**REQUEST**

Current Zoning: MX-1 INNOV (mixed-use residential, innovative)  
Proposed Zoning: MX-2 INNOV with 5-years vested rights (mixed-use residential, innovative)

Approximately 124.60 acres located along the east side of Tom Short Road, west of Red Rust Lane, and north of Ardrey Kell Road.

Staff recommends approval of this petition upon resolution of outstanding issues related to transportation and land use.

RZ-6

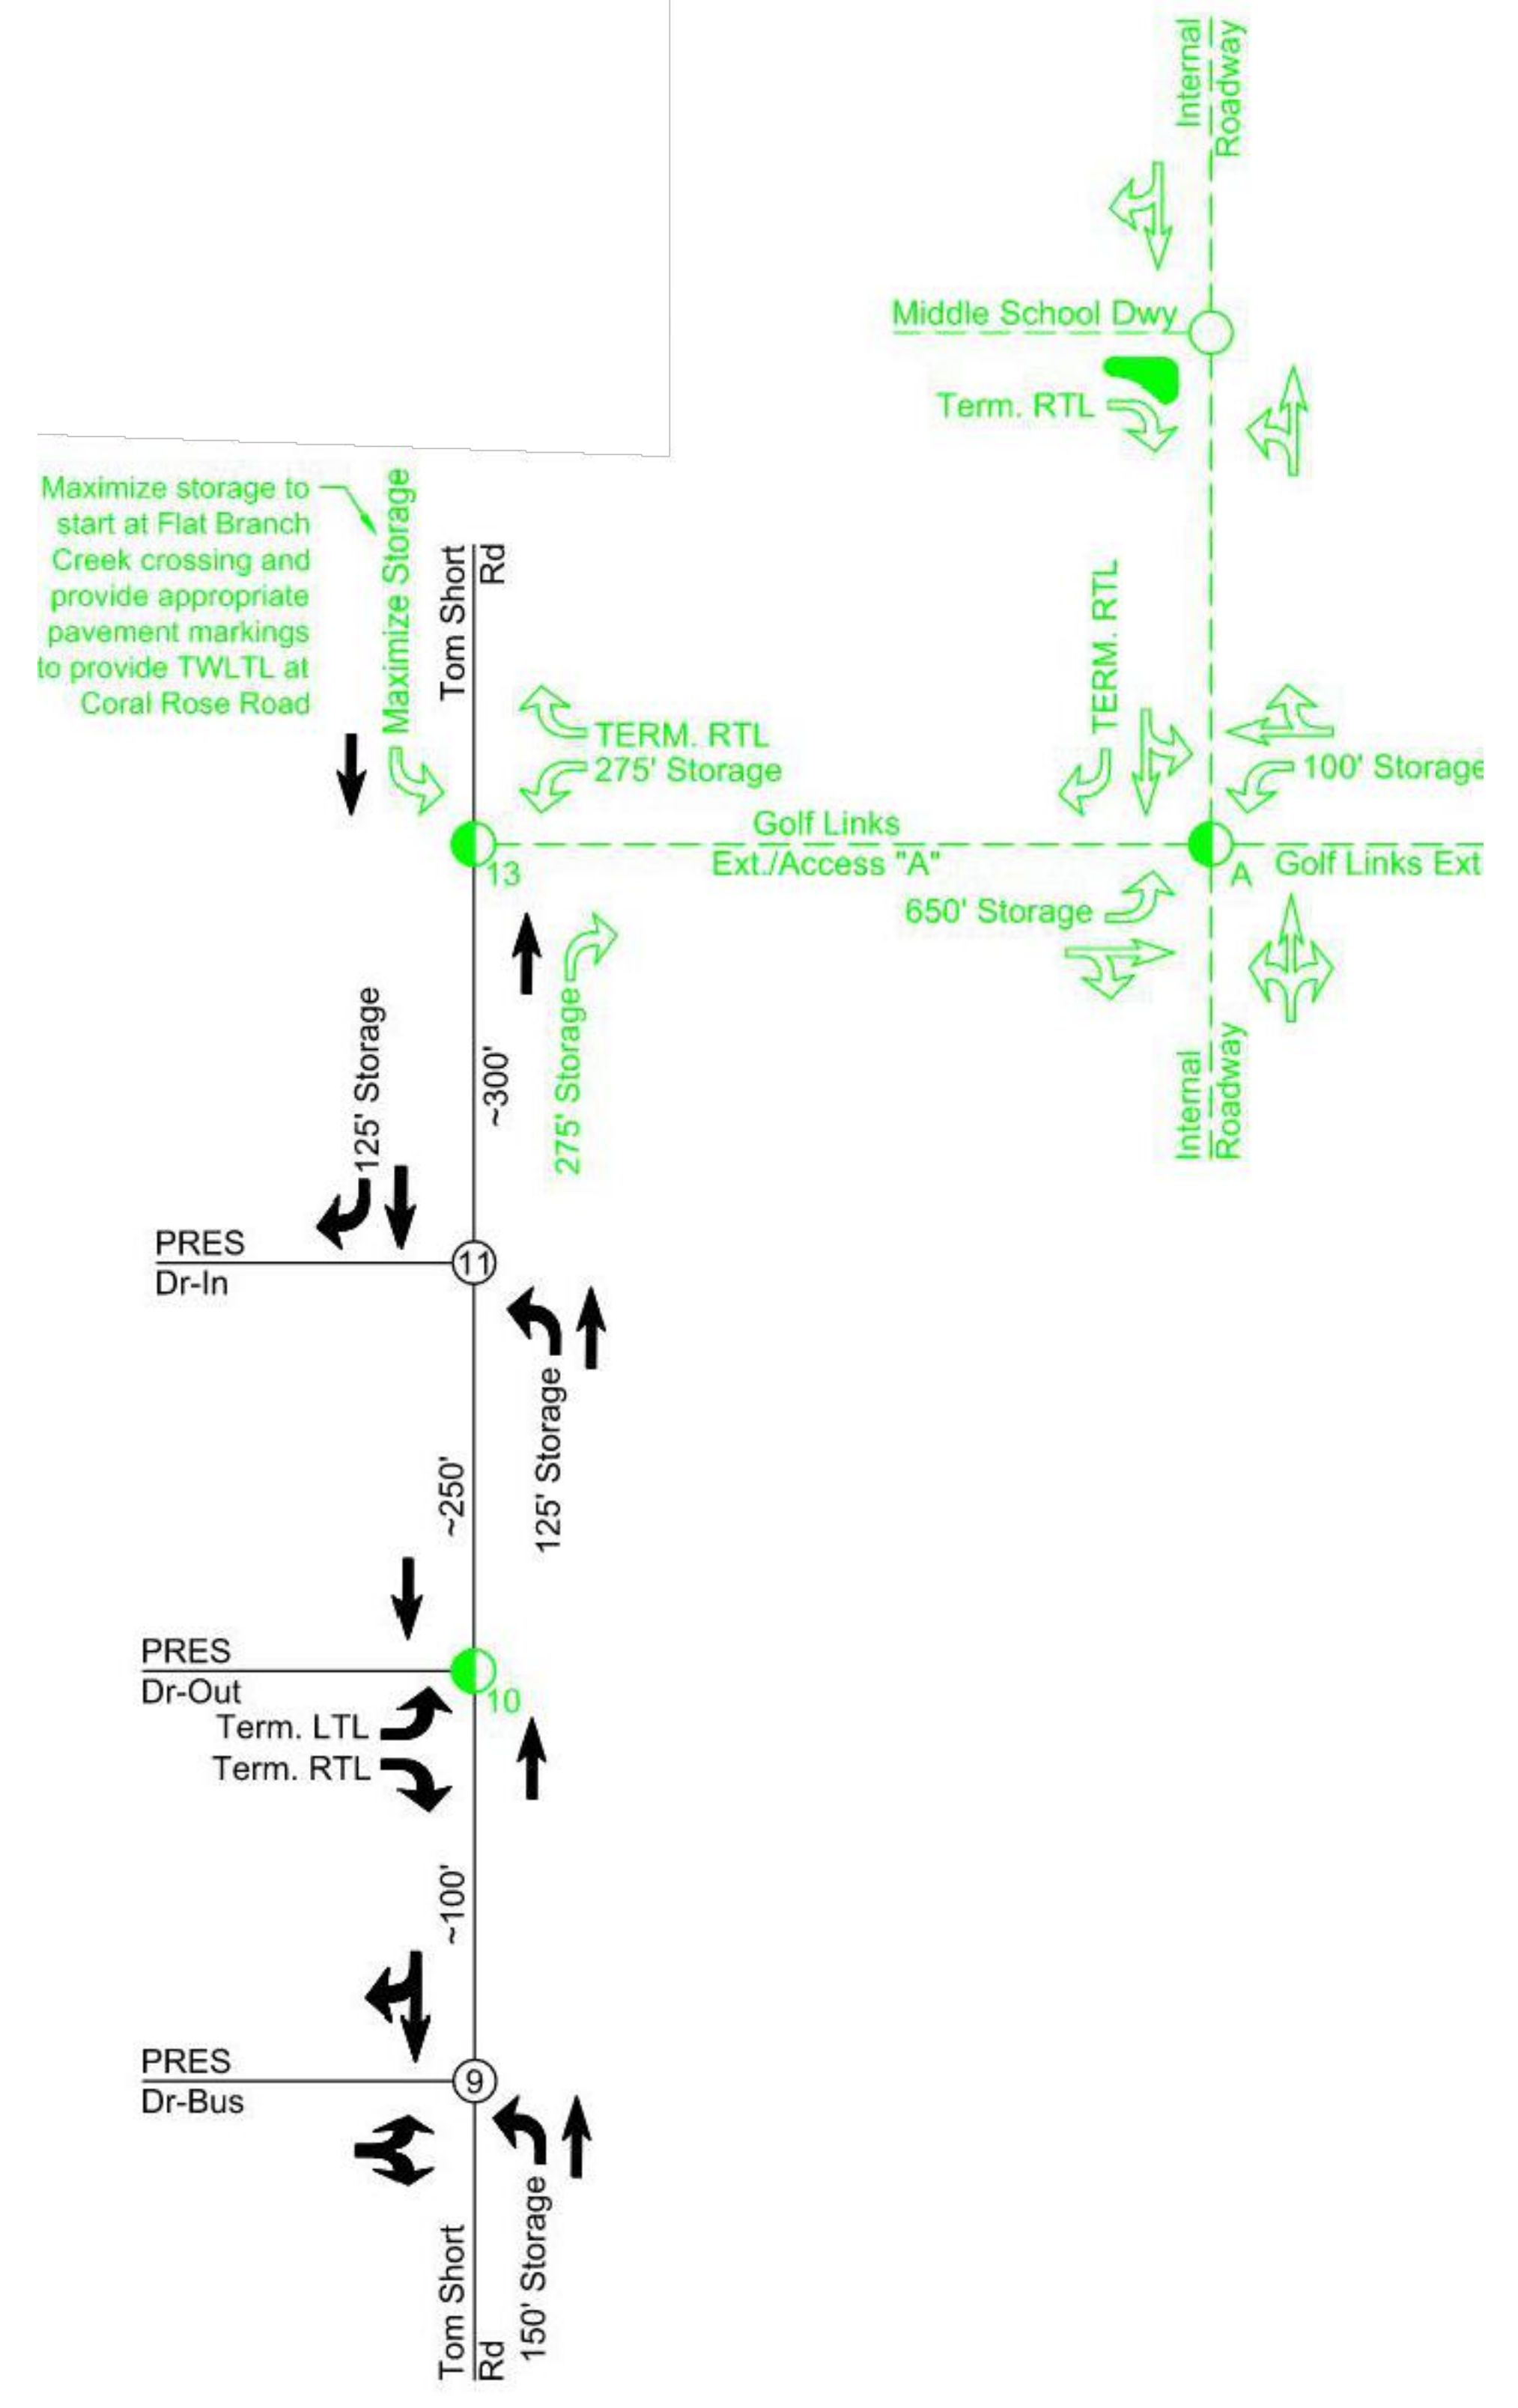
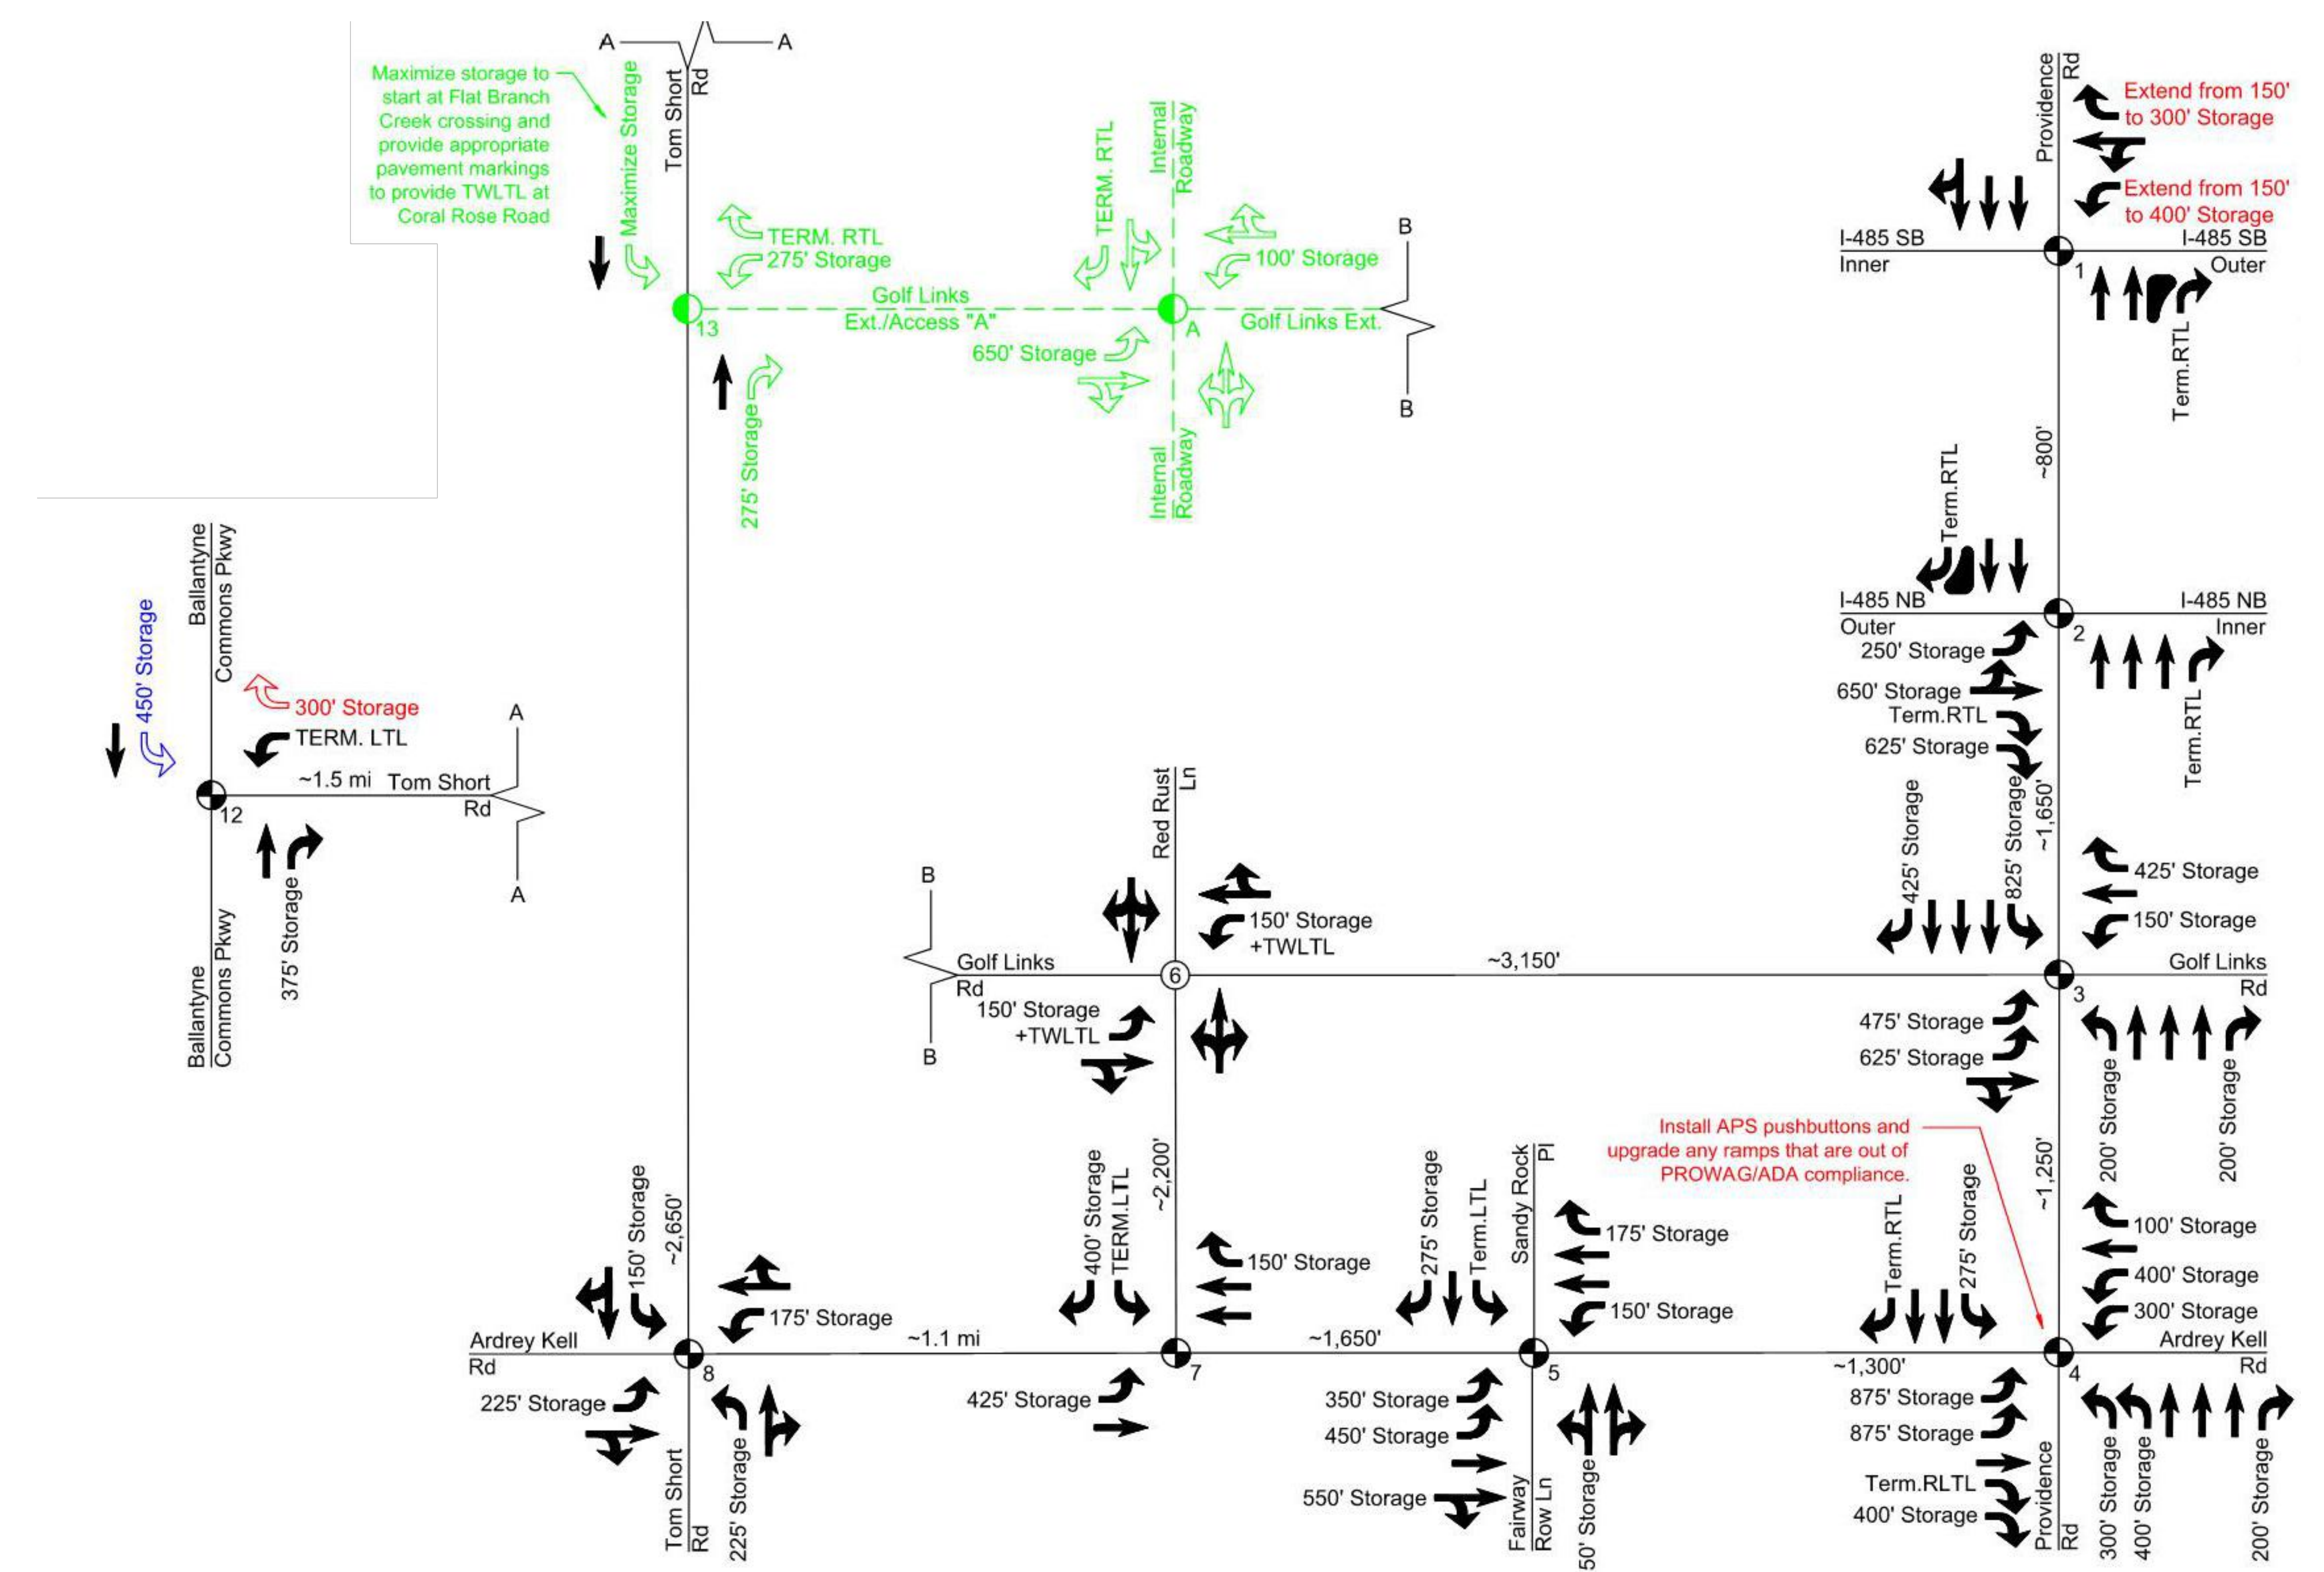
1. Revise transportation improvements notes for I-485 Southbound Ramp & Providence Road and Tom Short Road & Polo Ridge Elementary School Driveway-Out as specified by CDOT.
2. Revise the wording in the conditional notes for the internal intersection "A" to match the TIS as specified by CDOT.
3. Revise the transportation improvements for the second access on Tom Short Road as specified by NCDOT and update the TIS accordingly or remove the second access.
